7 August 2018

SSD7056 MOD 2 - BAY 11 ROOF - GABLE FRONT MODIFICATION TO CAMPBELL'S STORES 7-27 CIRCULAR QUAY WEST, THE ROCKS

03 NORTH ELEVATION  
SCALE 1:200

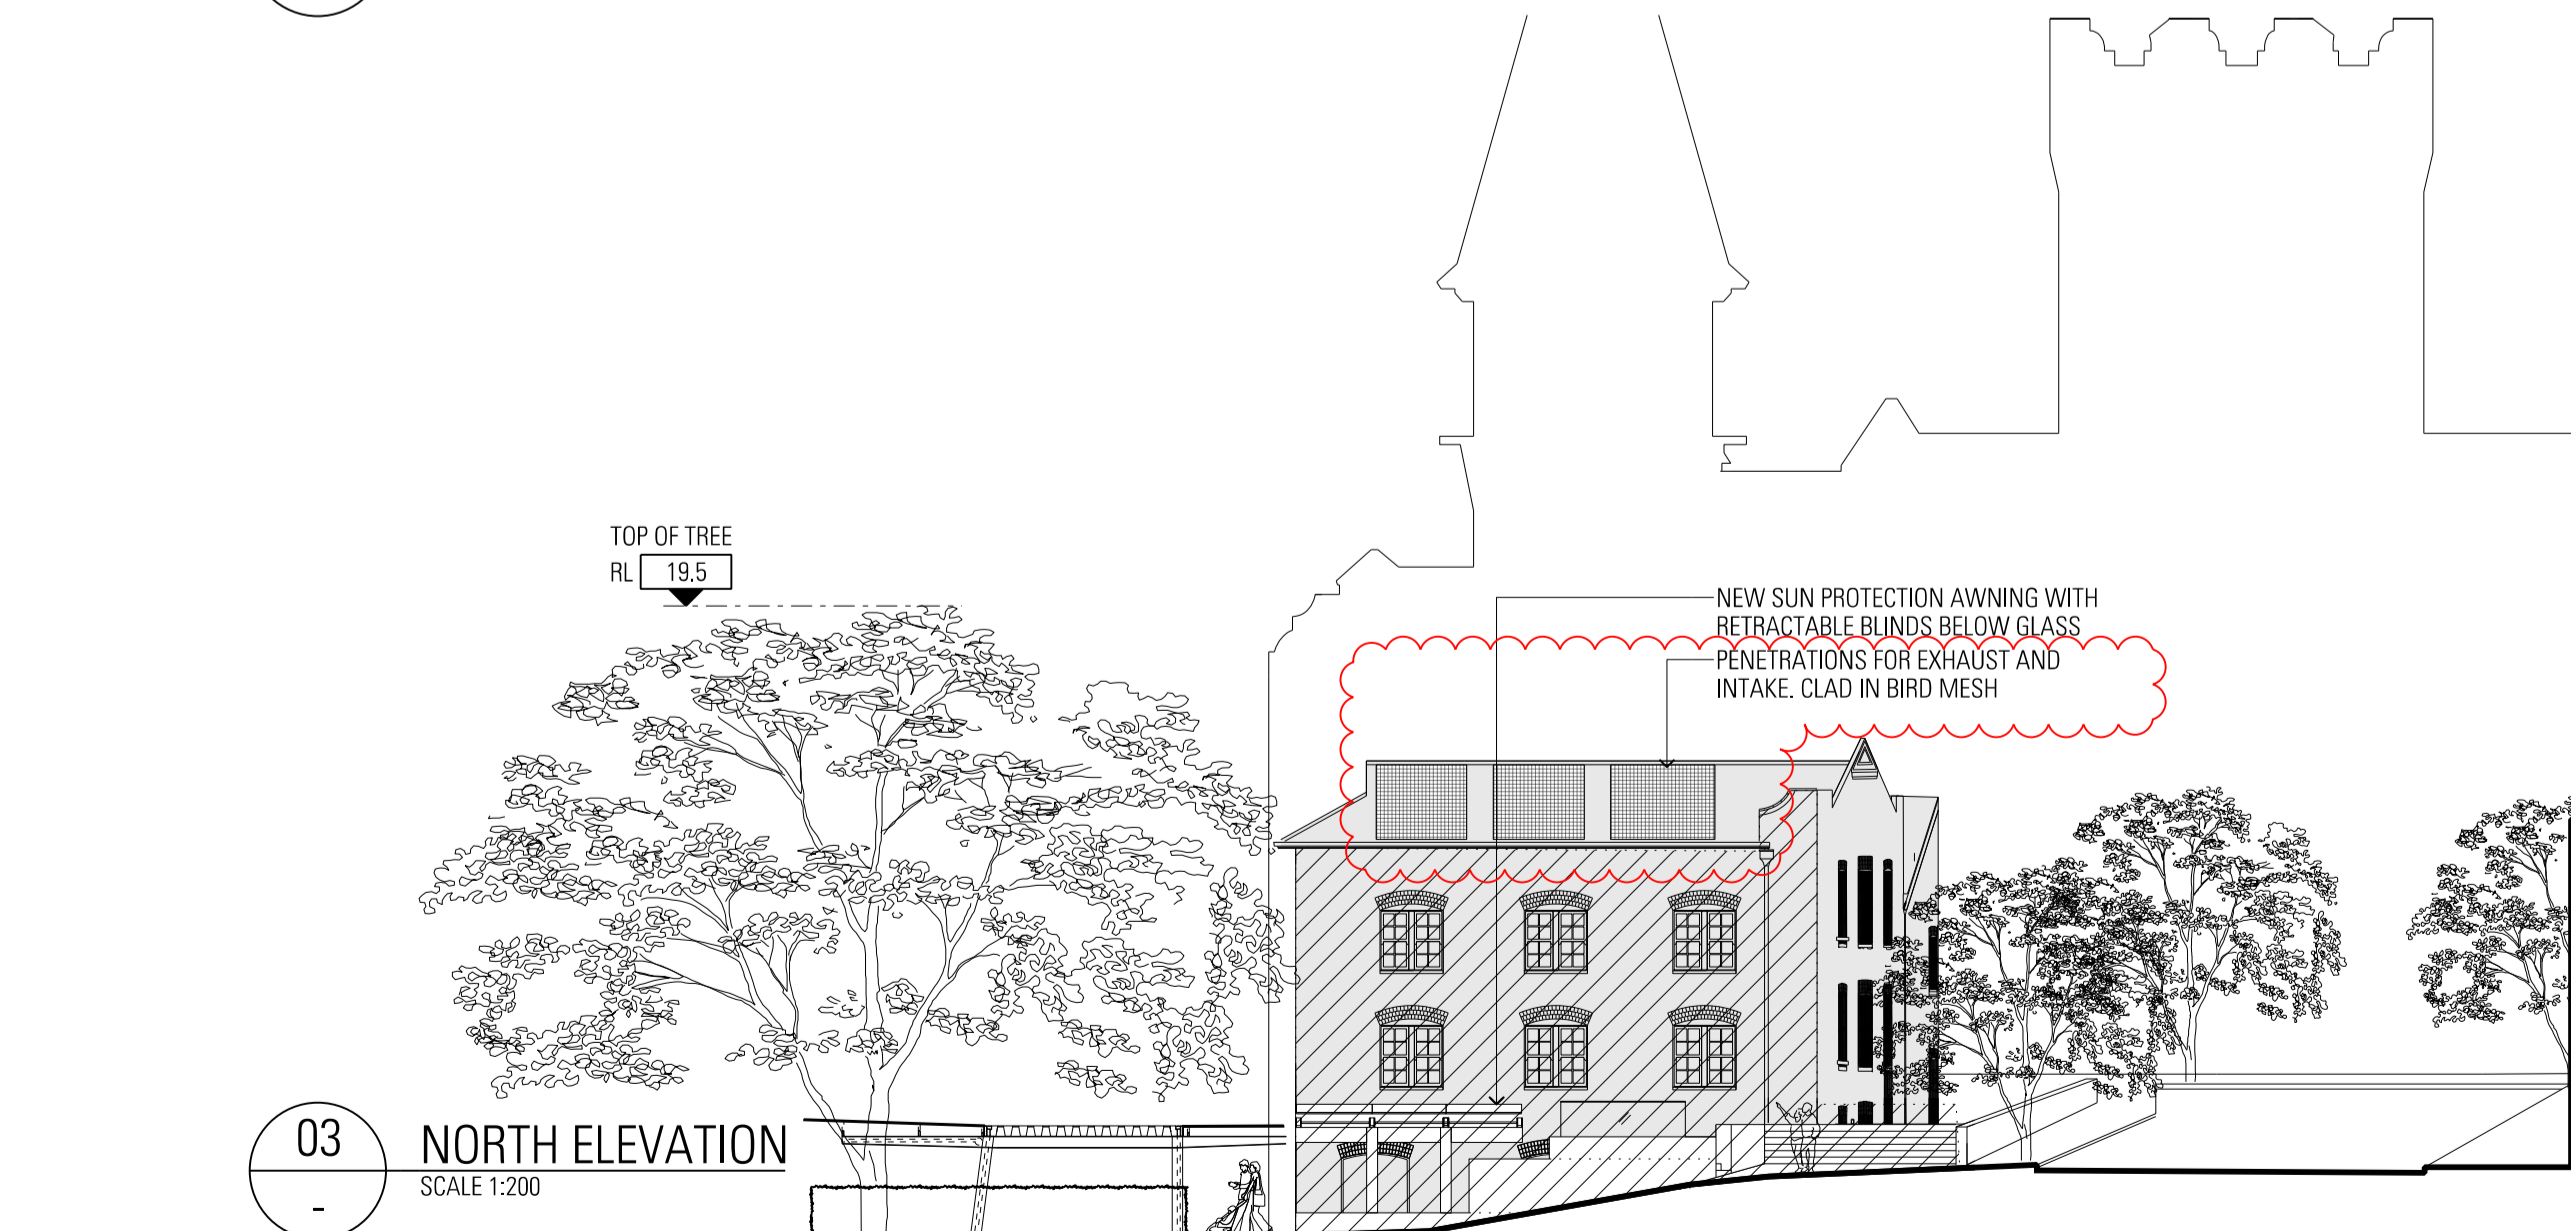
Further to our conversation with regard to the alteration to the gable front of the Bay 11 roof, we provide details of the proposal where the existing gable louvre/panel is to be replaced with a new metal louvre.

The initial comments raised concerned the necessity of the gable louvre replacement, the louvre colour, and subsequently, the size of the proposed louvre in terms of width.

In consideration of the above two options for louvre width, we comment in heritage terms:

- As the proposed louvre is a necessary new element within a heritage facade, it should be visually recessive and not draw the eye towards it. This can be achieved by the use of a minimum of materials and least differentiation, so as to not provide a distraction that draws attention to the observer.

In this regard, Option 1 provides a more uniform, simpler appearance than Option 2, which has a visually 'jarring' effect on the gable, by its division into three elements and two different material finishes, as well as different textures. The full width shape of Option 1 also relates more comfortably with the overall shape of the Bay 11 roof as a whole.

- On advice from the mechanical engineer (Northrop), the proposed louvre is required to be of a minimum area size to provide sufficient cross ventilation in addition to that provided through the roof for the mechanical equipment.
- The colour of the proposed louvre is to be amended to that of AS2700 colour 'Driftwood' (X34), which is a lighter colour to that of the bargeboard. This colour has been selected from the Campbells Stores palette of colours, and is used for the timber window frames and sills, and timber cladding.
- With reference to the attached drawing, there are two options for the width of the louvre:
 - Option 1: A louvre to the full width of the gable front
 - Option 2: A louvre with a minimum 'free air' size, resulting in a panel to each side.

We conclude that the choice of the colour of 'Driftwood' is suitable in the context of the selected colour palette of the Campbells Stores, and we recommend the Option 1, full width louvre is more visually acceptable in heritage, as well as design terms. We commend this proposal for approval by the consent authority.
